Your ref:	35 Melcombe Street Signage	Please reply to:	Mr Gregor Gault
Our ref:	24/01652/ADV	Tel No:	07814362226
		Fee Queries:	0207 641 6500;
		Email:	planningreception@westminster.gov.uk;
Maria Leuchten Studio Serre Architects La Serre Rue du Camp au Pretre St. Pierre du Bois GY7 9DS Guernsey		Incomplete Applications Town Planning & Building Control City of Westminster PO Box 732 Redhill, RH1 9FL	
		19 March 2024

Address: Basement And Ground Floor, 35 Melcombe Street, London, NW1 6AG,

Proposal: Display of an internally illuminated fascia lettering measuring 35cm x 20cm; and an internally illuminated projecting sign measuring 65cm x 65cm.

Drawing **Proposed Signage**  
 individual letters

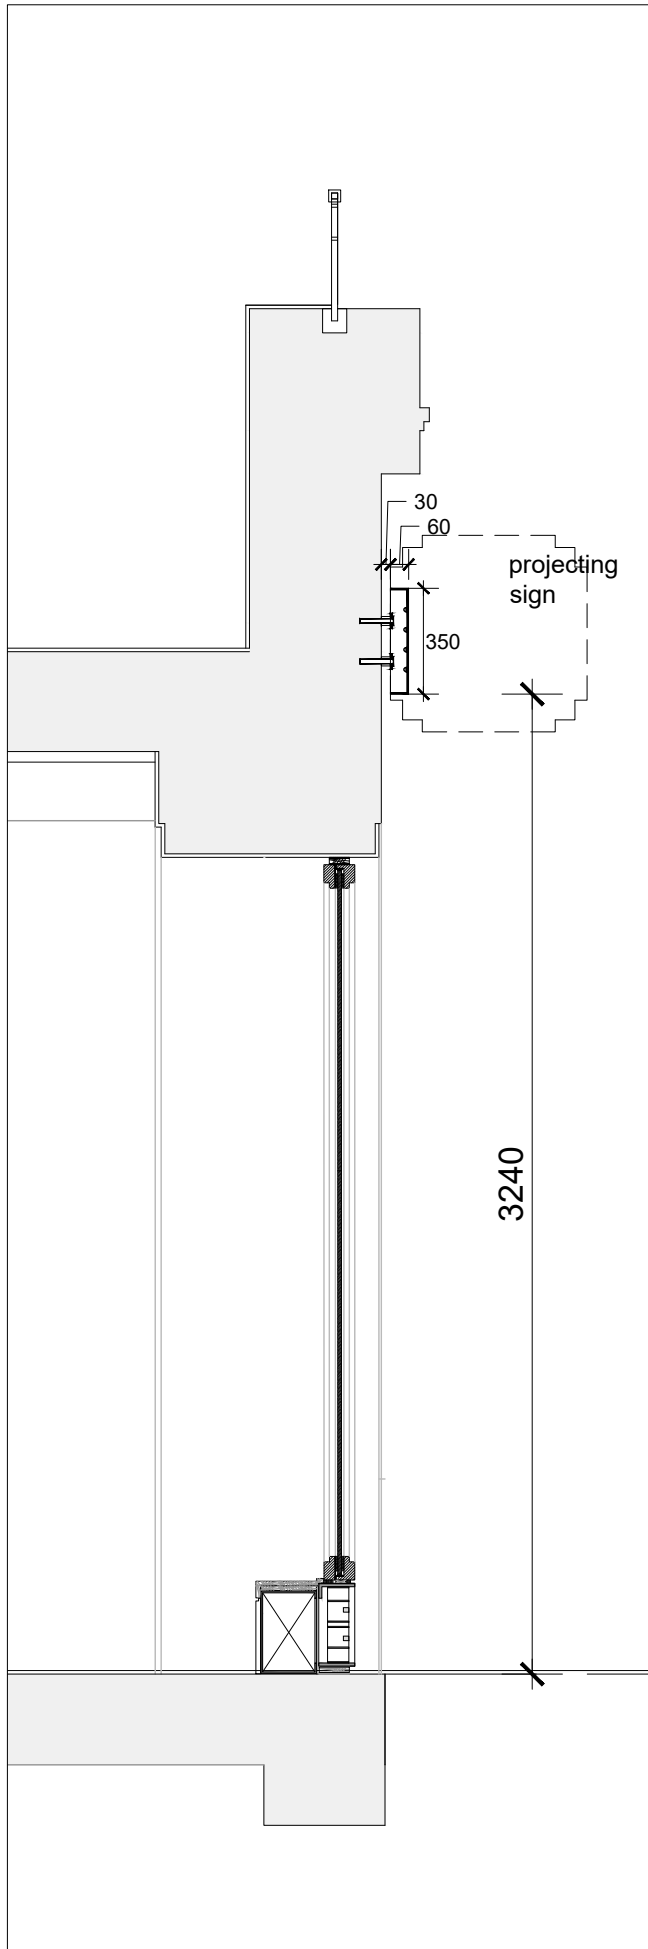
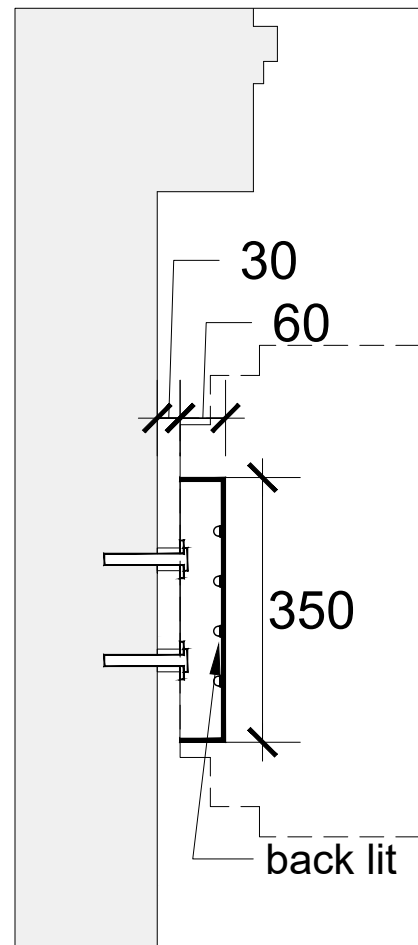
- 1 Please update the detail drawing of the proposed lettering sign to show the dimensions of the sign as one rather than individual letters (width and height).
- 0 *Please collate all requested information in a single submission and send to planningreception@westminster.gov.uk. Sending your documents individually will not speed up the process. Please do not upload to the planning portal as this causes duplication and may delay the processing of your application. Thank you.*
